Appeal NO: ~~ACP~~ App-32254-25Defer Re O/H ☐Having considered the contents of the submission dated/ received 24/11/25
fromIngelese Stuijts I recommend that section 131 of the Planning and Development Act, 2000
be/not be invoked at this stage for the following reason(s): No new planning issuesE.O.: Daniel O'ConnorDate: 25/11/25

An Bord Pleanála Planning Reference	ABP-322154-25 (or PL10.322154)
KCC Planning File	25/6003
Name	Briskalagh Ltd.
Address	In the townlands of Acragar, Ballyconra, Ballycuddihy, Ballyroe, Ballyroe (Grace), Ballyroe (Maher), Baunaniska, Boherkyle, Briskalagh, Brittas, Clone, Coolnapisha, Curraghduff, Freshford, Freshford Lots, Graigueswood, Grange, Huntstown, Kilmanagh, Knockeenglass, Knockown, Moatpark, Monabrika, Monavadaroe, Moneenaun, Oldtown, Oldtownhill, Parksgrove, Picketstown, Rathealy, Sart, Sweethill, Tobernapeastia, Tullaroan, Upperwood Demesne, Co. Kilkenny.

I wish to reiterate my concerns relating to the proposed Briskalagh Wind Energy Development near Kilmanagh, Co. Kilkenny, as put forward in my letter to ABP, dated 21-04-2025.

Figure 36. Flood map with water depths for Design River System and Q_{1000cc} design flow.

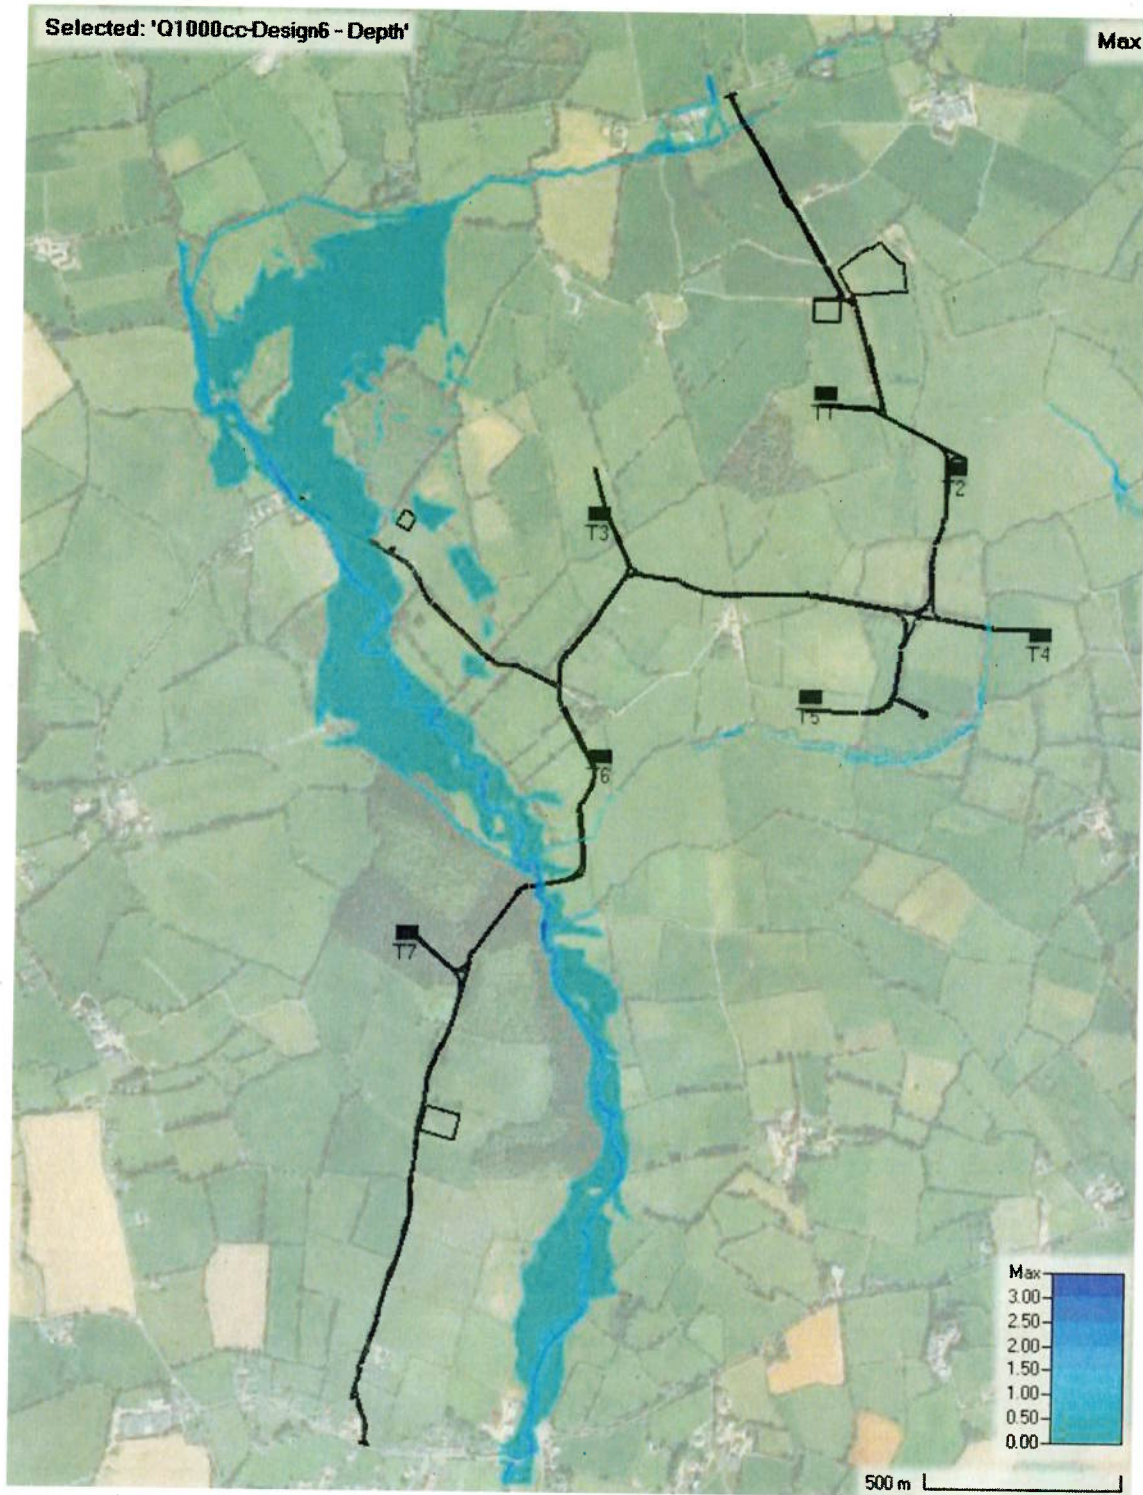
- The new information from Fluvio makes me very concerned for the location of the proposed substation and work/spoil area, within the 50m buffer zone along the River to the West, and with streams located to the North and an area that is prone to flooding in the East. Surely, a substation should be located away from a buffer zone and a floodplain should be respected for what it is. (Page 57 Figure 36 and Page 59 Figure 38 flood map)

Fig. 36 gives flood map for the extreme 1000-year flood.....'The main access roads affected are in the vicinity of turbines T7, T8 and T9 where there is significant flooding with relatively high water depth. It is important that the turbine hardstands at these locations should be elevated constructions with ground levels 05m higher than the extreme flood level. The access roads to these elevated hardstands should be ramped at a suitable gradient.'
